CITY OF ALBUQUERQUE

March 3, 2023

**Re: Adagio Apartments 6800 Oakridge St NW
Erosion and Sediment Control Plan
Engineer's Stamp Date 2/27/2023 (C09E014)**

**TEMPORARY EROSION AND  
SEDIMENT CONTROL PLAN**

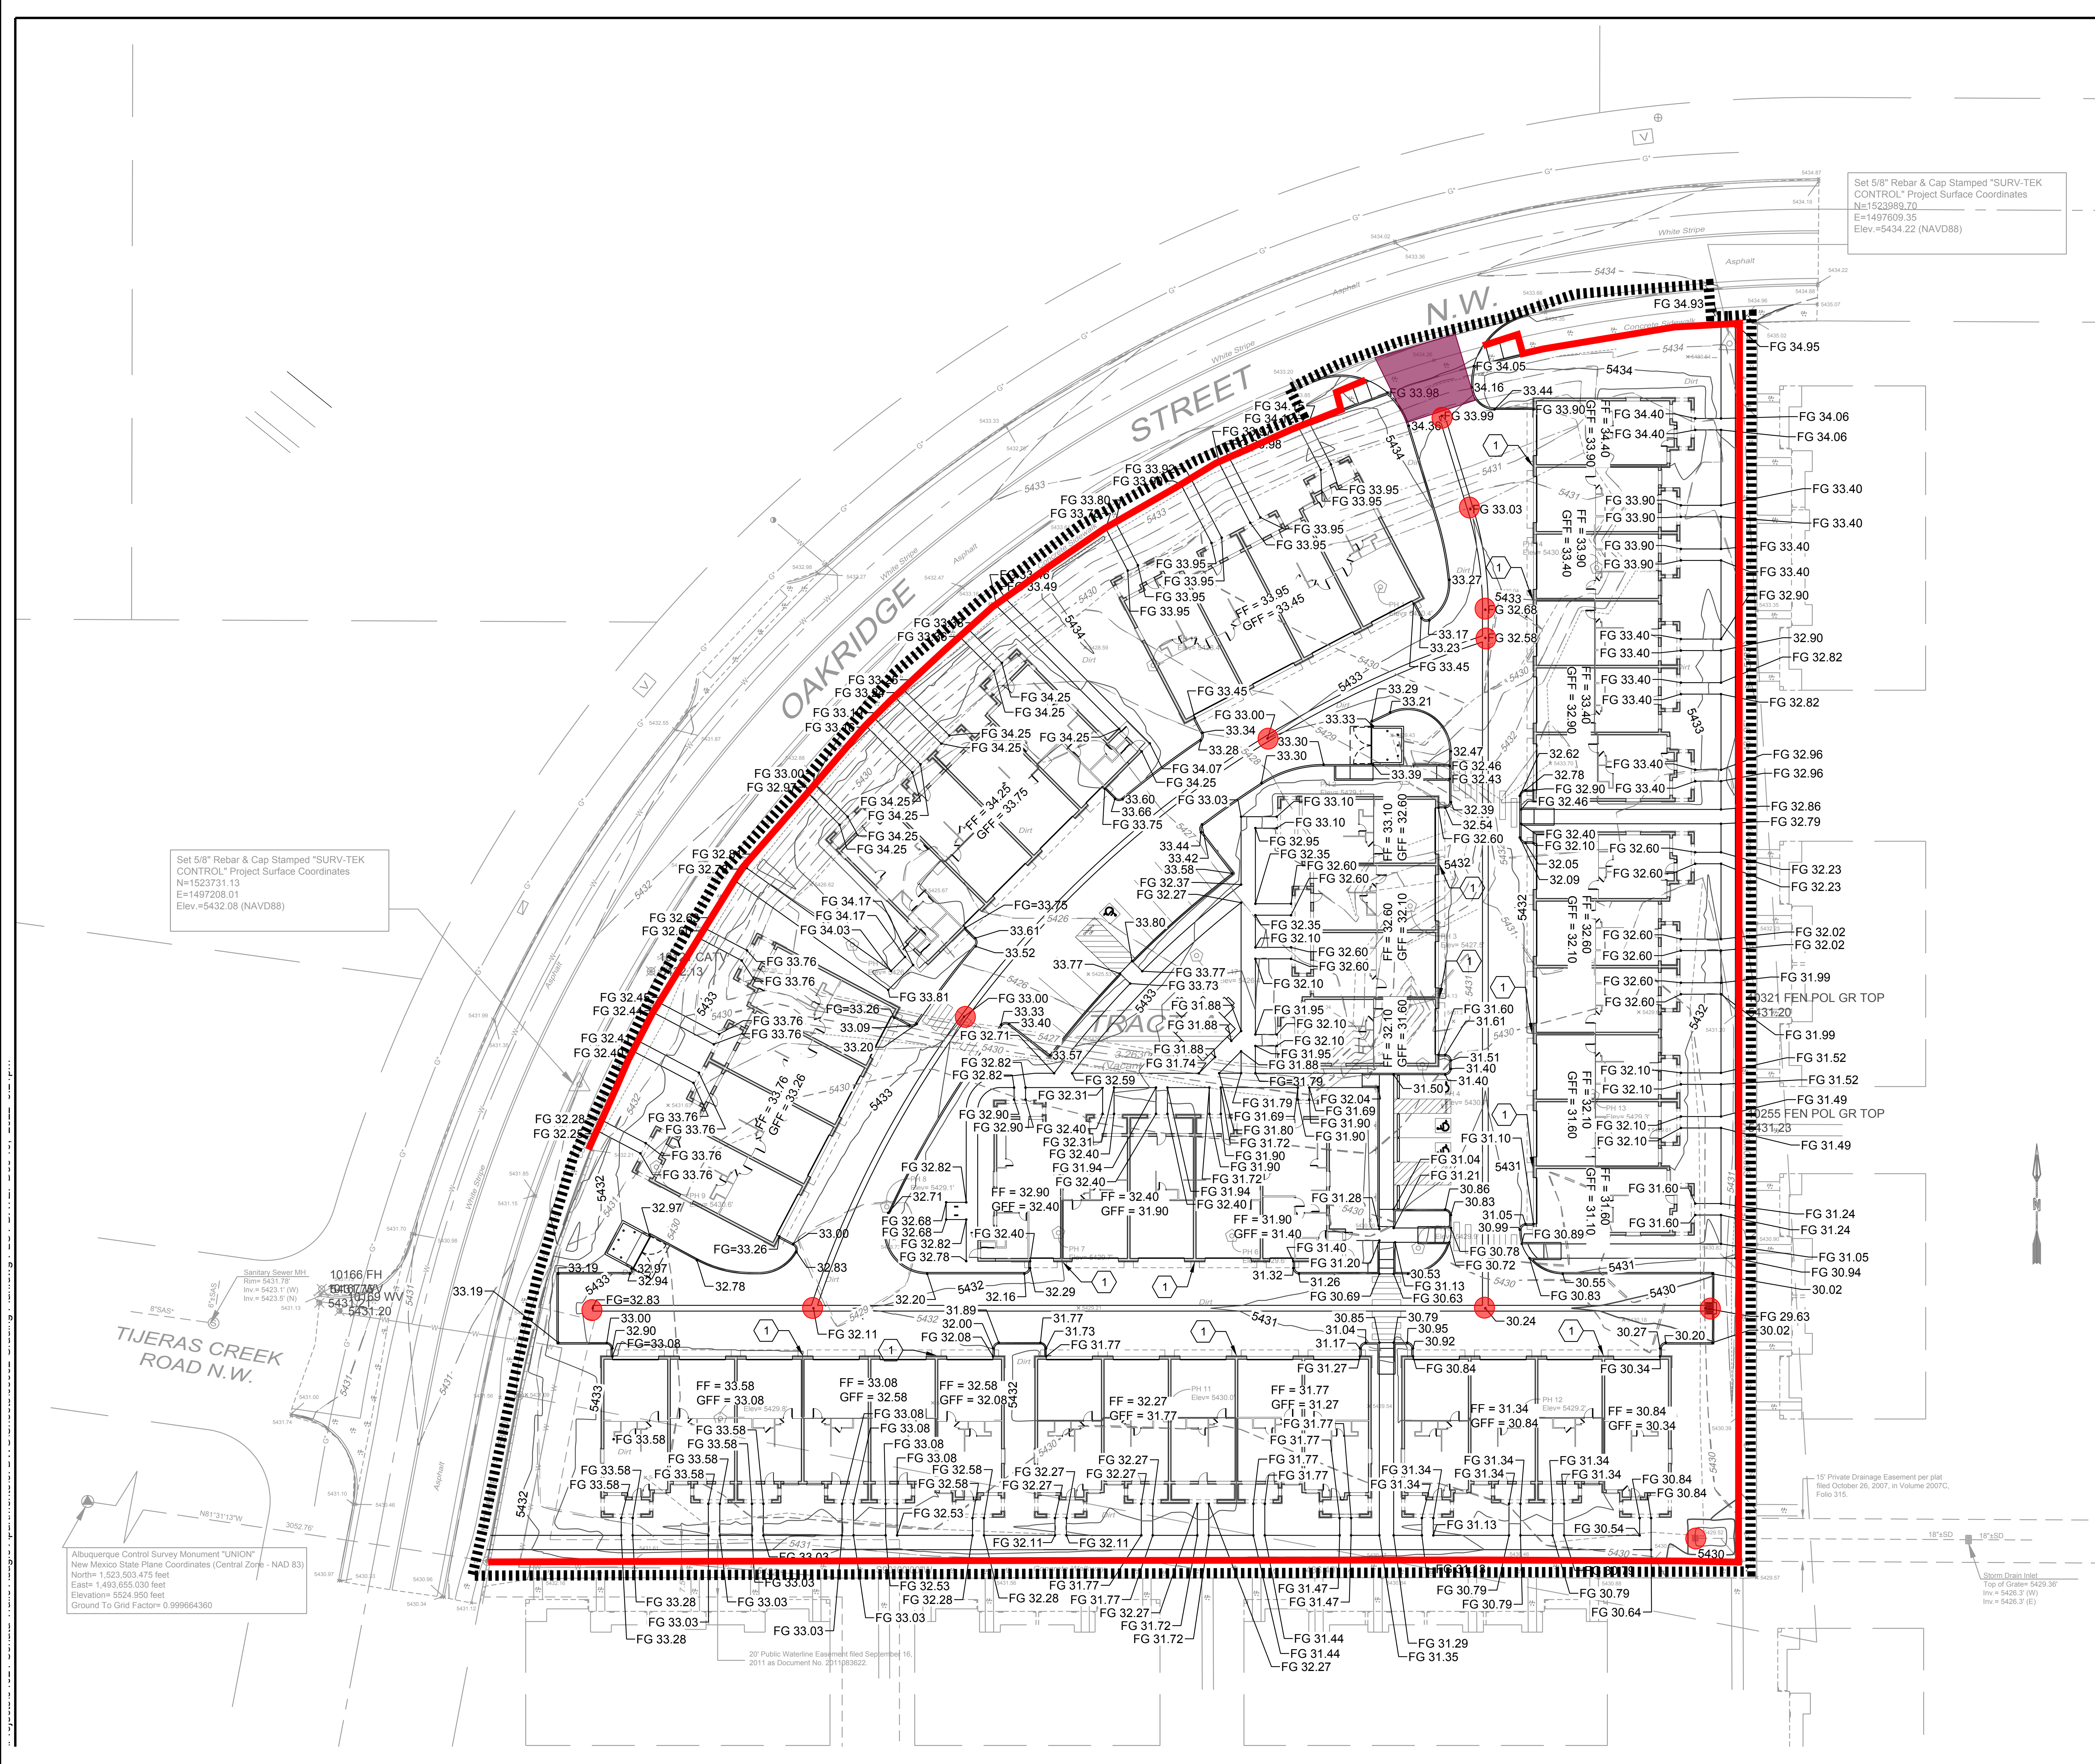
1. The ESC Plan can't be approved until after Hydrology approves the G&D Plan for each specific purpose, Site Plan, Grading, Building Permit, and Work Order. The only purpose Hydrology has approved so far is Rough Grading. The existing and proposed grades must be shown on the ESC Plan, and they must agree with the Grading Plan approved by Hydrology (CGP7.2.4.b.ii).
